Application No: AW/325/21/HH
Site Address: Blue Haze 37 The Drive Aldwick PO21 4DT
Description of works: Erection of single storey side/rear extension, front porch extension and detached garage to front
(This application may affect the character and appearance of the Craigwell House, Aldwick Conservation Area)

Thank you for your internet representation made on 10th November 2021 which has been recorded as an objection with the comments as follows:

PROPOSED GROUND FLOOR PLAN

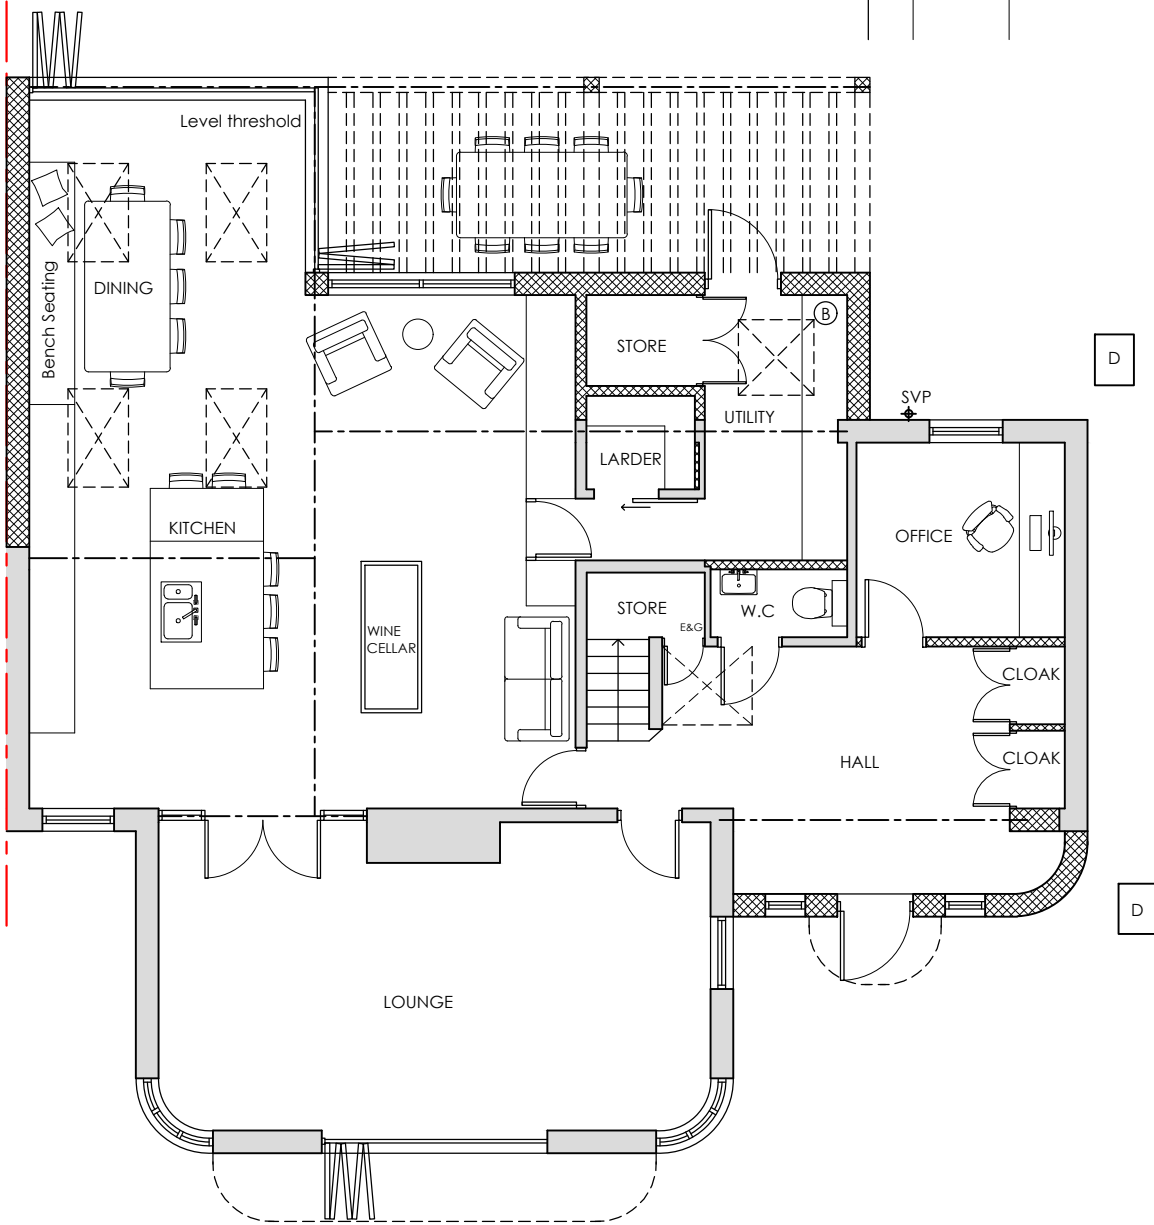
The rear extension will bring the building significantly closer to our boundary and have an adverse affect upon our privacy. The current screening is at risk of being removed with the building extension and subsequent likely use.

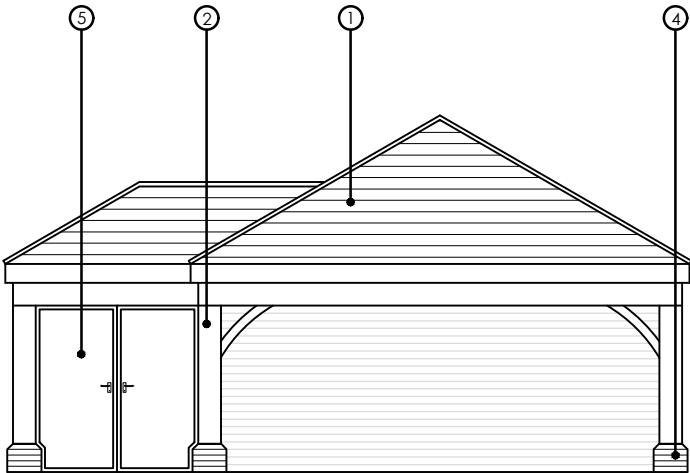
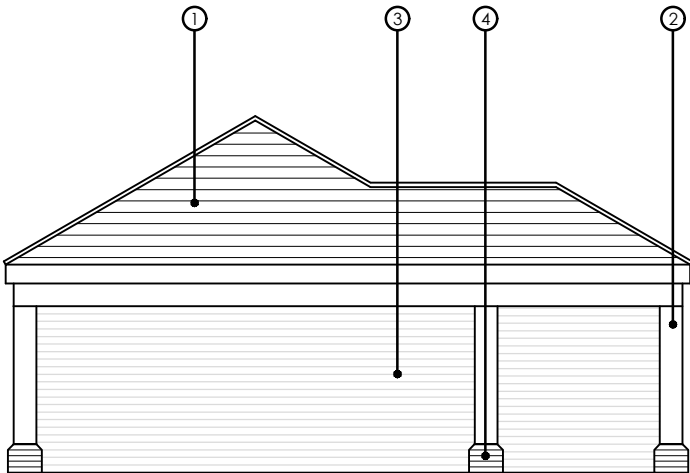
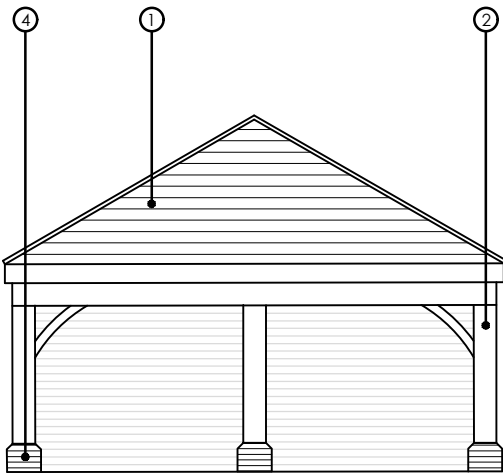
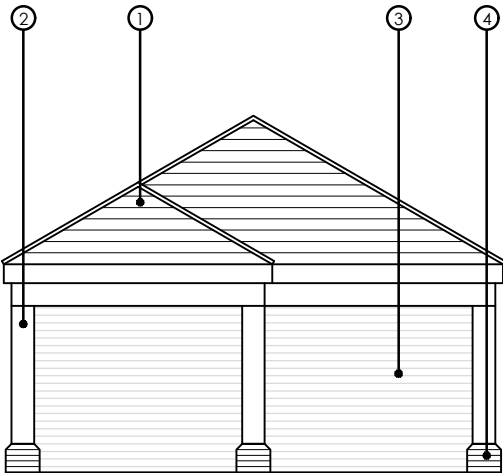
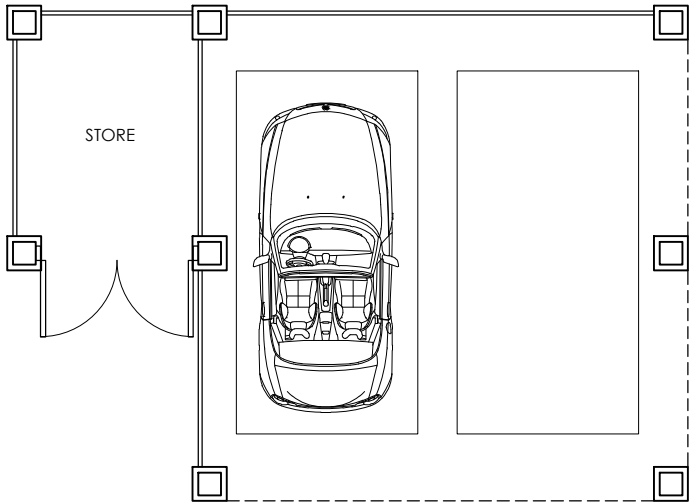
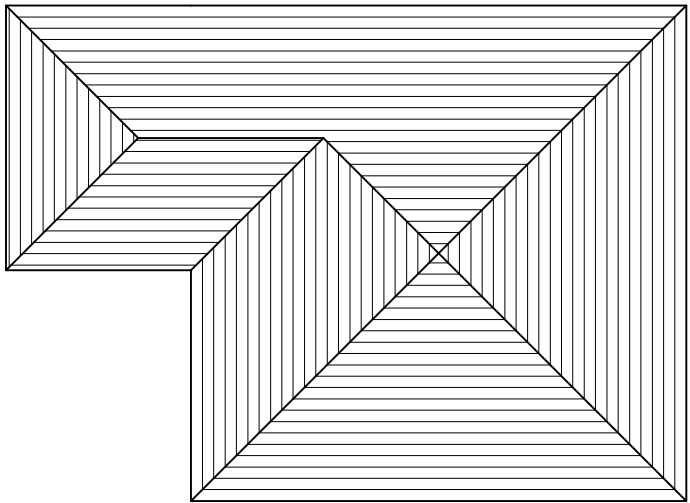
The double car port is out of character both in style, having timber cladding and it's position in the front garden, with the other properties along The Drive in the Craigwell Conservation Area.
